Porte Cochere Green Wall

4.7 Signage - Tower

**GENERAL NOTES**

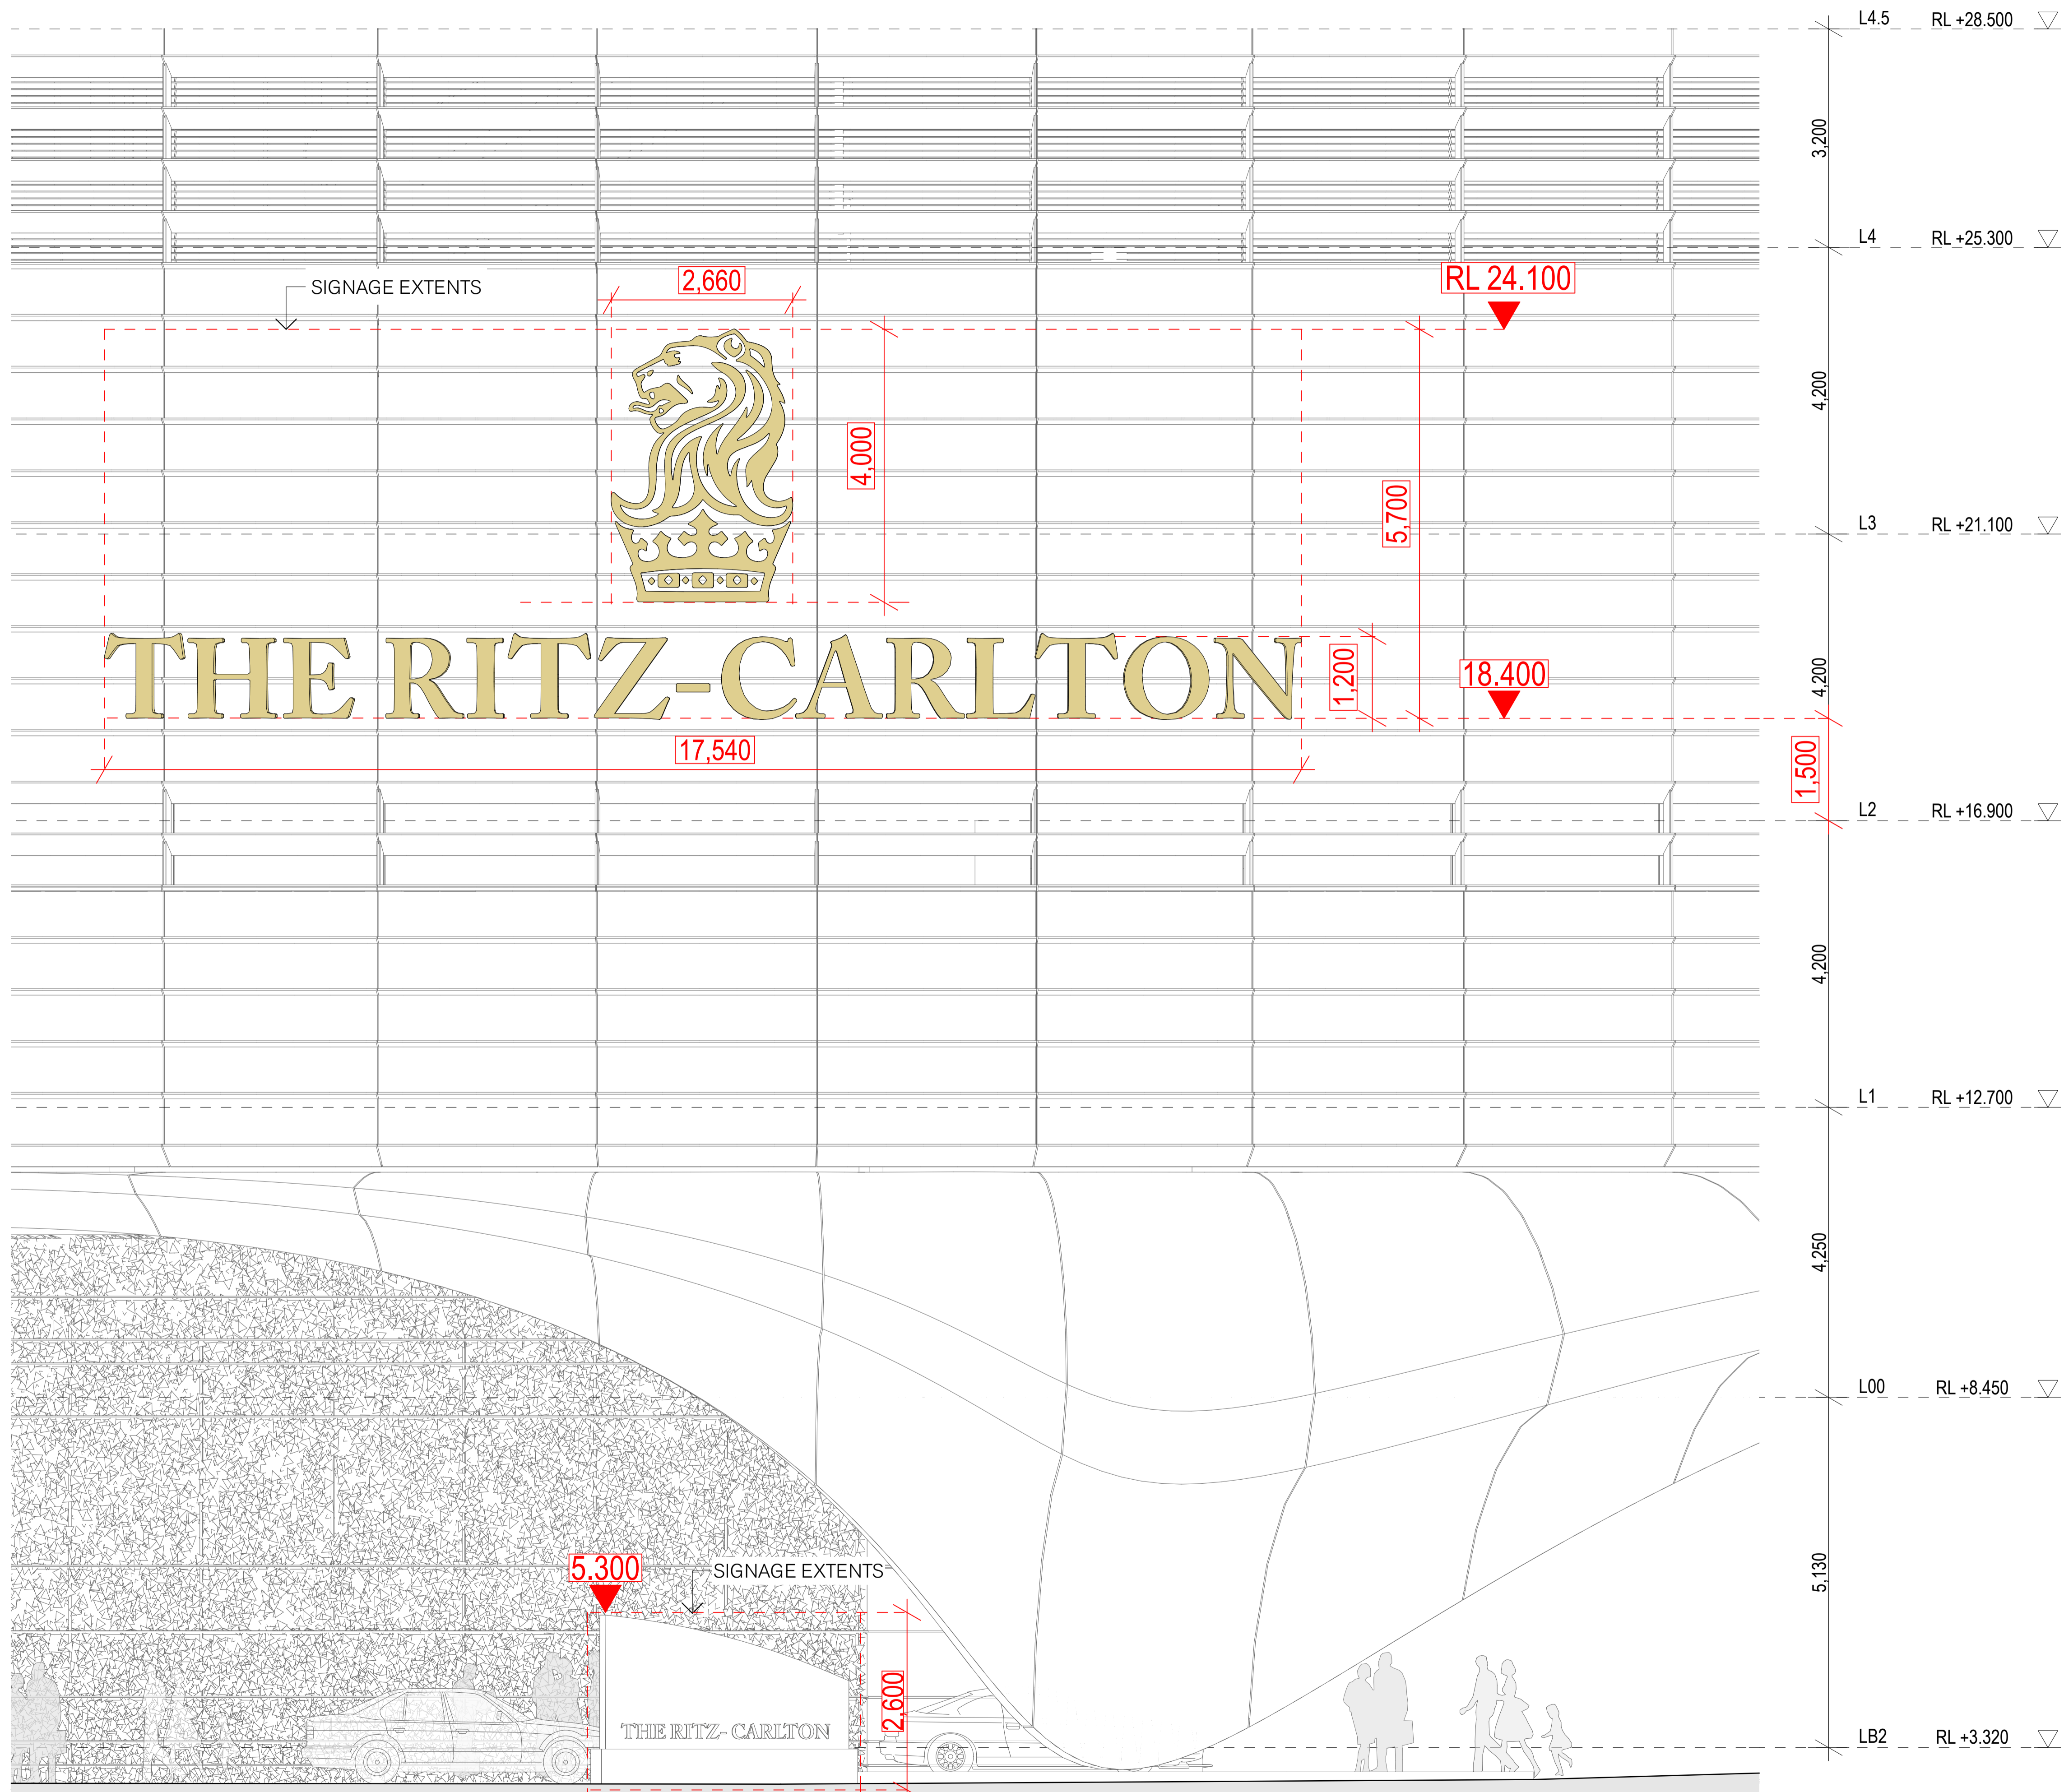
Department of Planning item:  
"Consider reducing the size of the roof-level signage on the tower having regard to the proportions of the roof and other comparable roof-top signage approvals within Darling Harbour"

The proposed sky signage has been reduced from 8.2m diameter to 7.9m diameter to ensure it is appropriately sized with consideration of other sky signage within Darling Harbour.

The dimensions of the Tower signage has been reduced since formal lodgement from 8.2m to 7.9m diameter, giving an area of **49m2**. At RL +237.000m (AHD) this provides ration of tower height to signage height of **30:1**.
